1 b) CMP

City of Sydney Comment - 1 b)

Figure 9: Hickson Road elevation showing proposed location of new awnings.
Source: Tonkin Zulaikha Greer Architects

SHORES SHEDS SOUTH ELEVATION (HICKSON ROAD) - PROPOSED

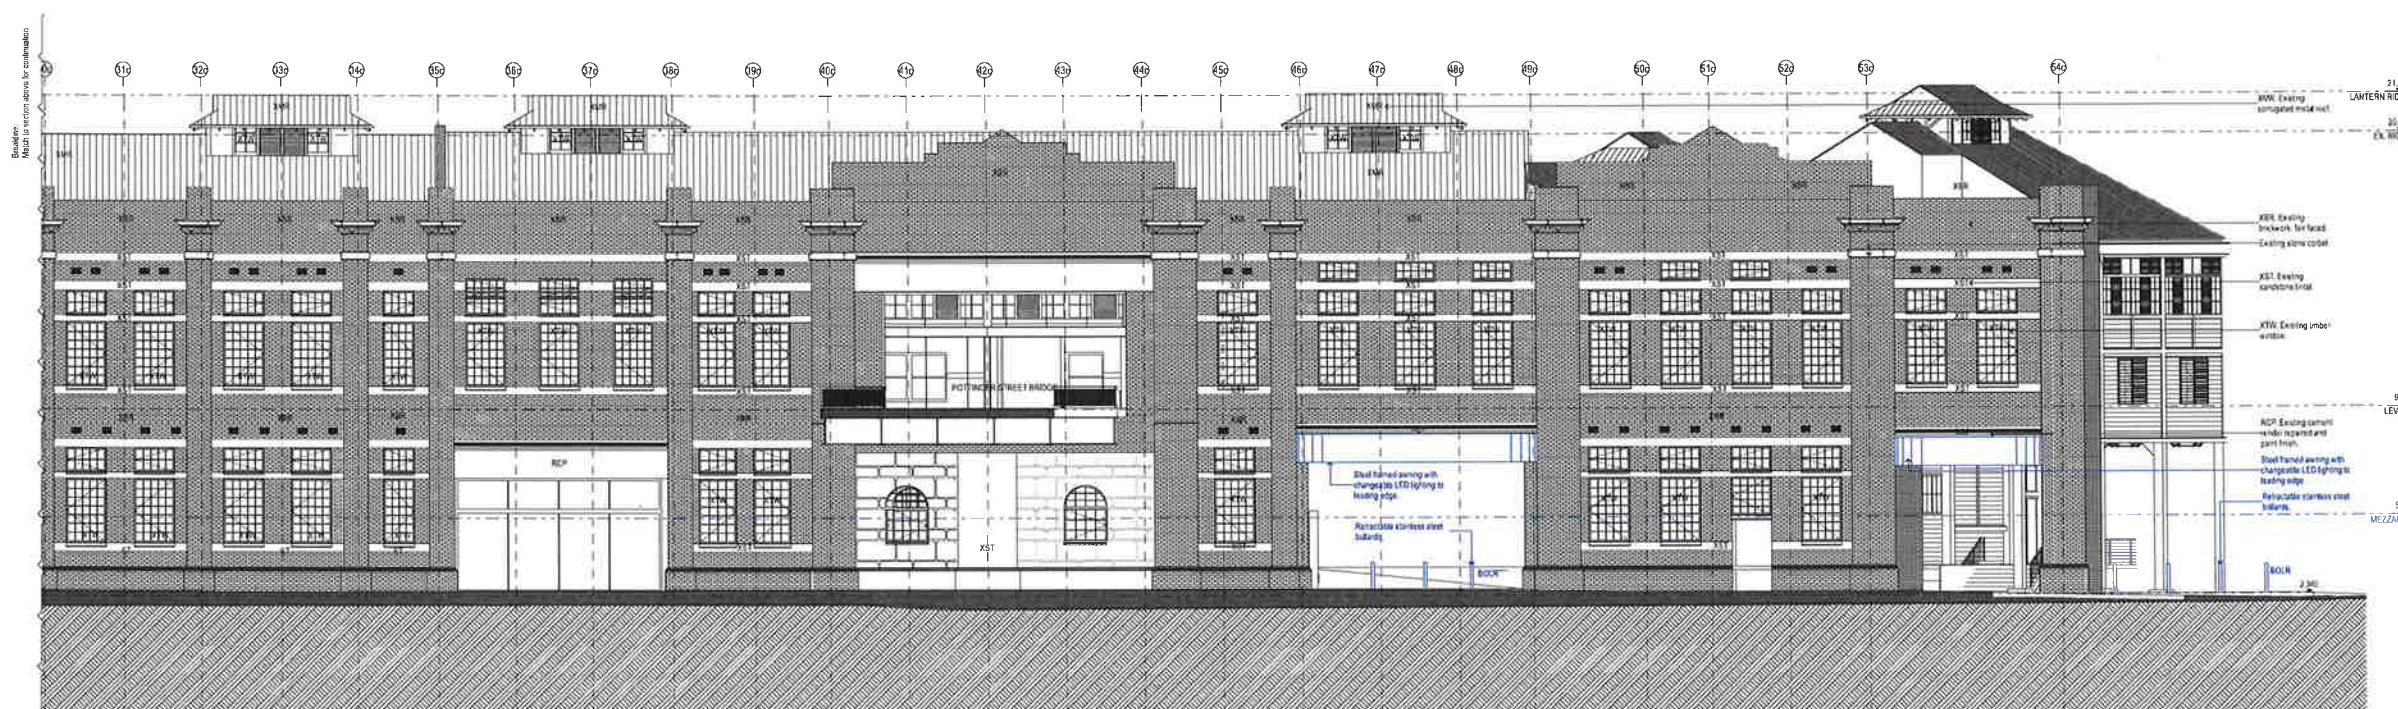
It is noted that awnings are not characteristic of the Hickson Road elevation of the Walsh Bay Shore Sheds. If the Department is minded to approve new awnings, they should be simply detailed, confined to entries and be sympathetic to the industrial character of the facades. The awnings should be designed with input from the applicant's heritage consultant.

The new awnings to Hickson Road will be simply detailed, confined to entries and sympathetic to the industrial character of the original facade. The design of the awnings will be further developed with input from the applicant's heritage consultant.
